## **FIRE RISK MANAGEMENT, INC**

# **Memo Report**

**Subject: Fire Safety Evaluation of Residential Property Located at 521 Cumberland Ave., Portland, ME**

FIRST FLOOR  
521 CUMBERLAND AVE

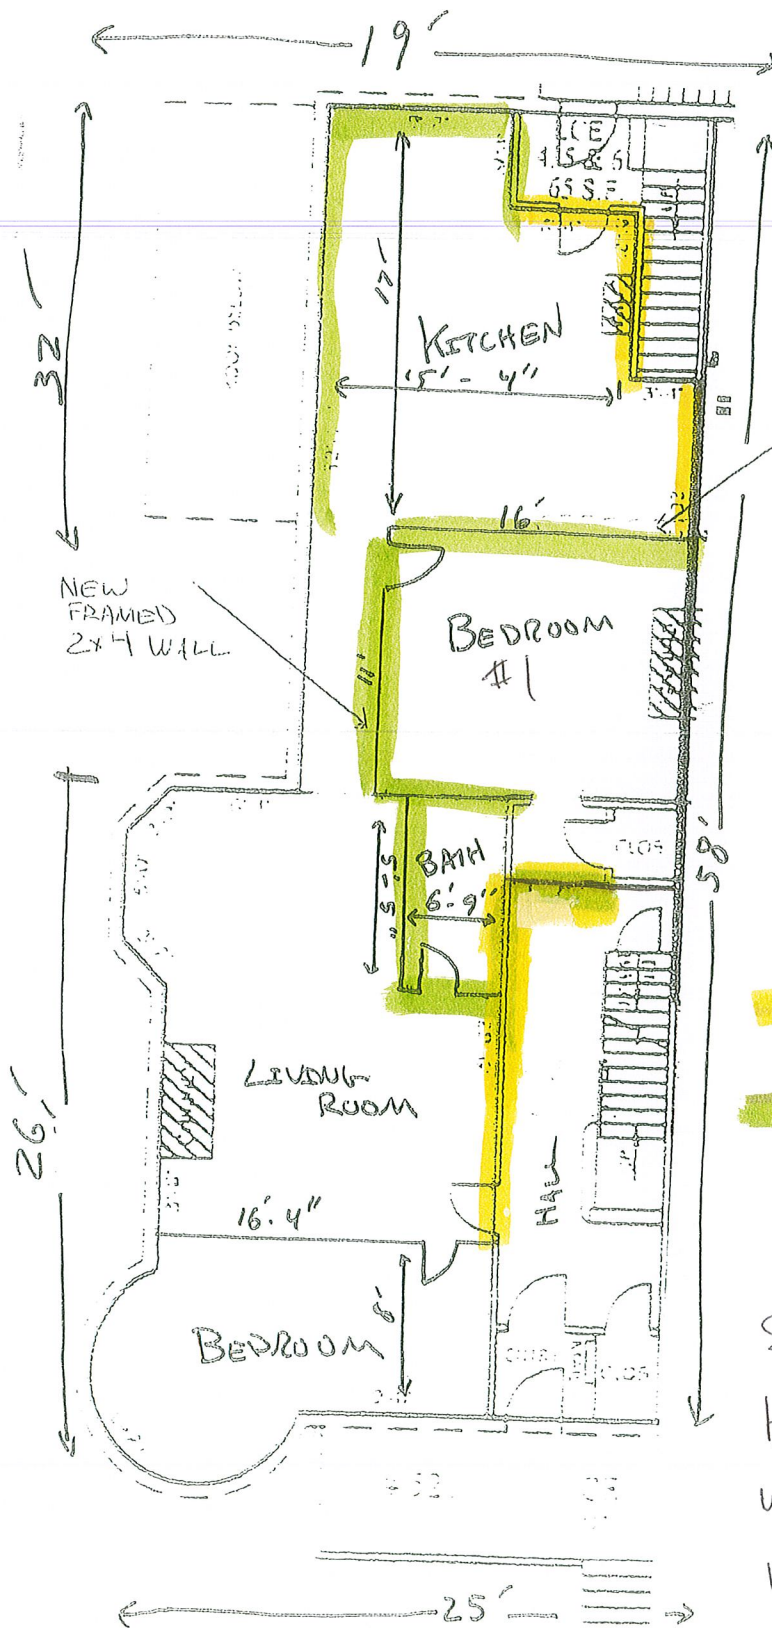
1. Ensure that the two stair enclosures are isolated from the rest of the building by barriers that have at least a 1-hour fire resistance rating. Although the codes would not require this building to have two separate stair enclosures, since the 2<sup>nd</sup> enclosure does exist and unless there are plans to remove this, it still represents a vertical opening that spans all floors and would be required to be separated by a 1-hour fire barrier anyway. As such, it is recommended that both stairs be maintained and provided with the necessary fire separation as outlined above.

2. All barriers that separate individual apartments should have at least a 1-hour fire resistance rating. Due to the heavy timber construction of the floor/ceiling assemblies, it is recommended that any openings in these assemblies be sealed with a listed fire penetration seal material, using a configuration that the manufacturer indicates has been listed as providing the 1-hour fire resistance. These actions should allow for the maintenance of the required fire separation between apartments. Any items that penetrate the floor/ceiling assemblies (piping, ducting, etc.) should be of non-combustible materials and/or meet the required flame spread rating for non-combustibility. Equally, the barrier(s) separating these apartments from the adjacent apartment complex shall also be constructed/repared to ensure that a 1-hour fire resistance rating is maintained.
